THE ROUNDLE RESIDENTS' ASSOCIATION LTD

Planning Application FP/193/17/HH
Proposed extensions to 5 Roundle Avenue, Felpham, West Sussex.

Proposed North Elevation

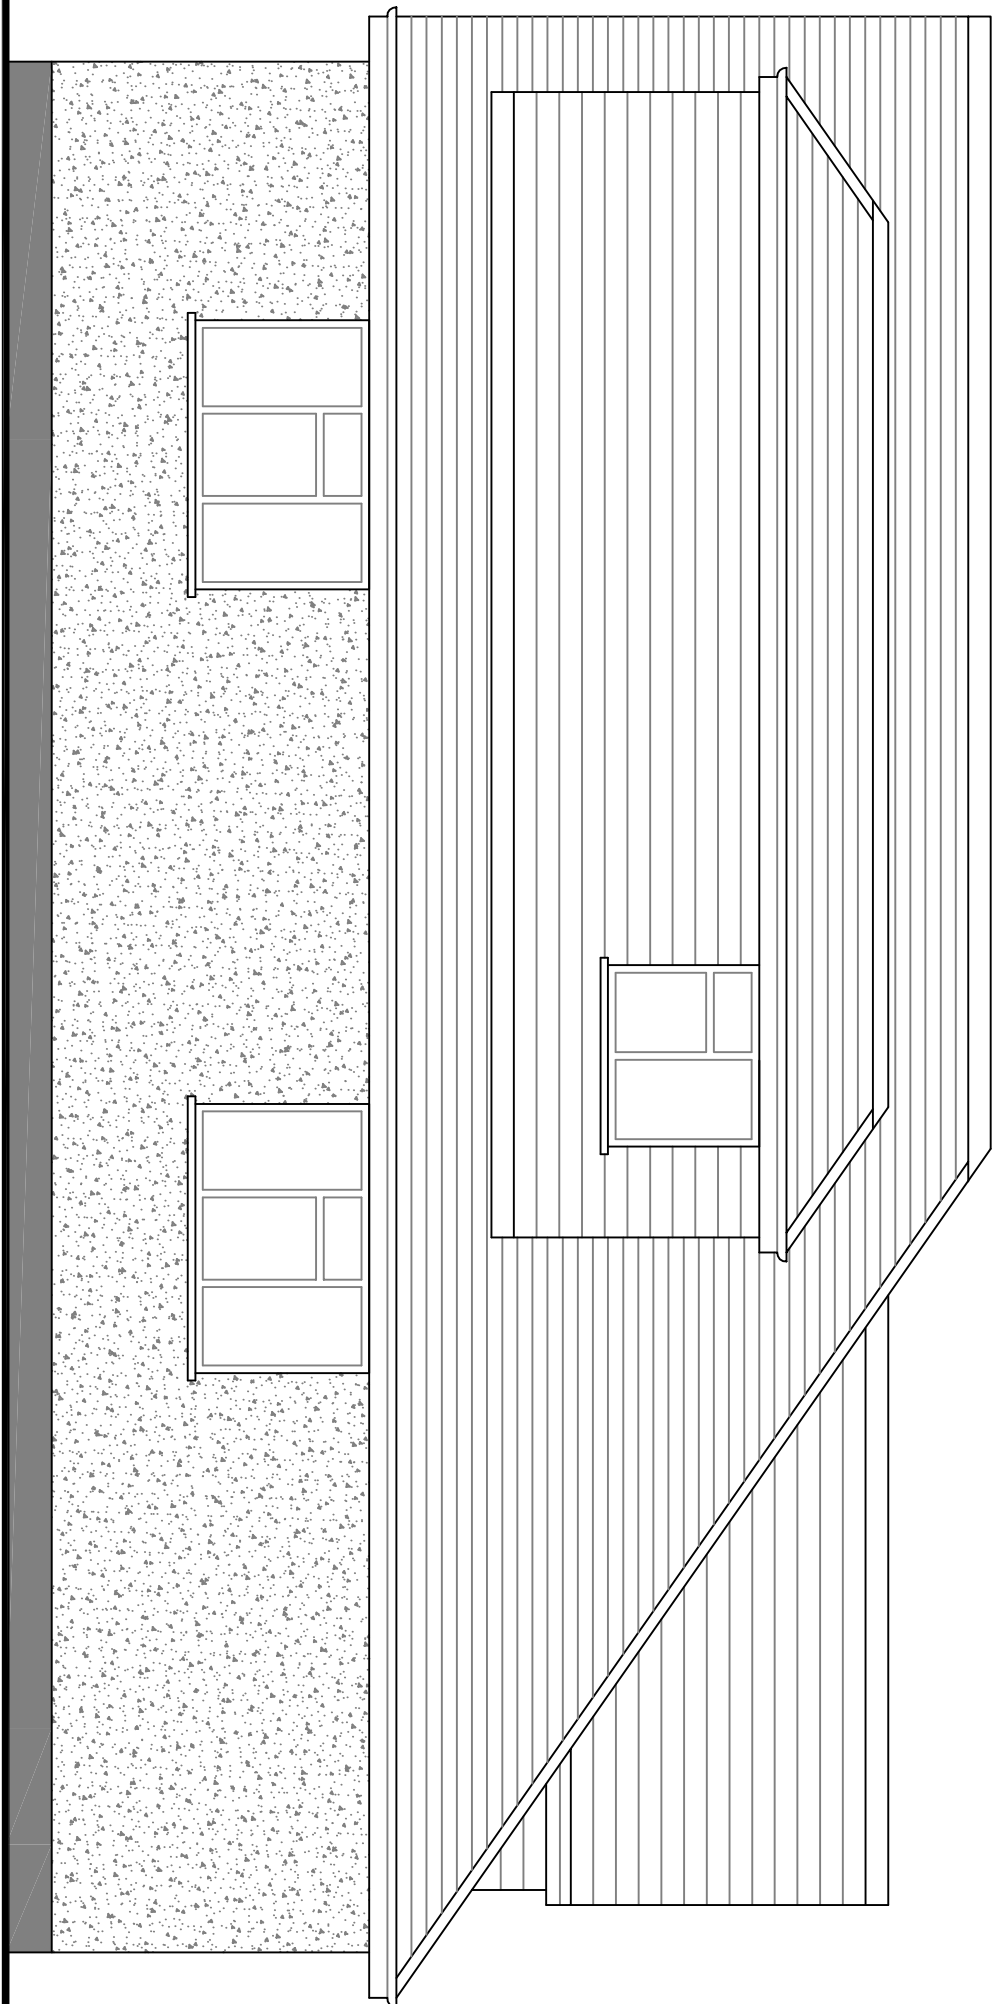
2. The proposed Dormer extensions on both the North and South sides of the above property are unsympathetic in design and would be visually very dominant - being out of proportion to the property and other existing dwellings within our Association. This proposal would have an adverse effect on the visual amenity of the locality, neighbouring properties and generally impact adversely upon the character and street scene of the area.
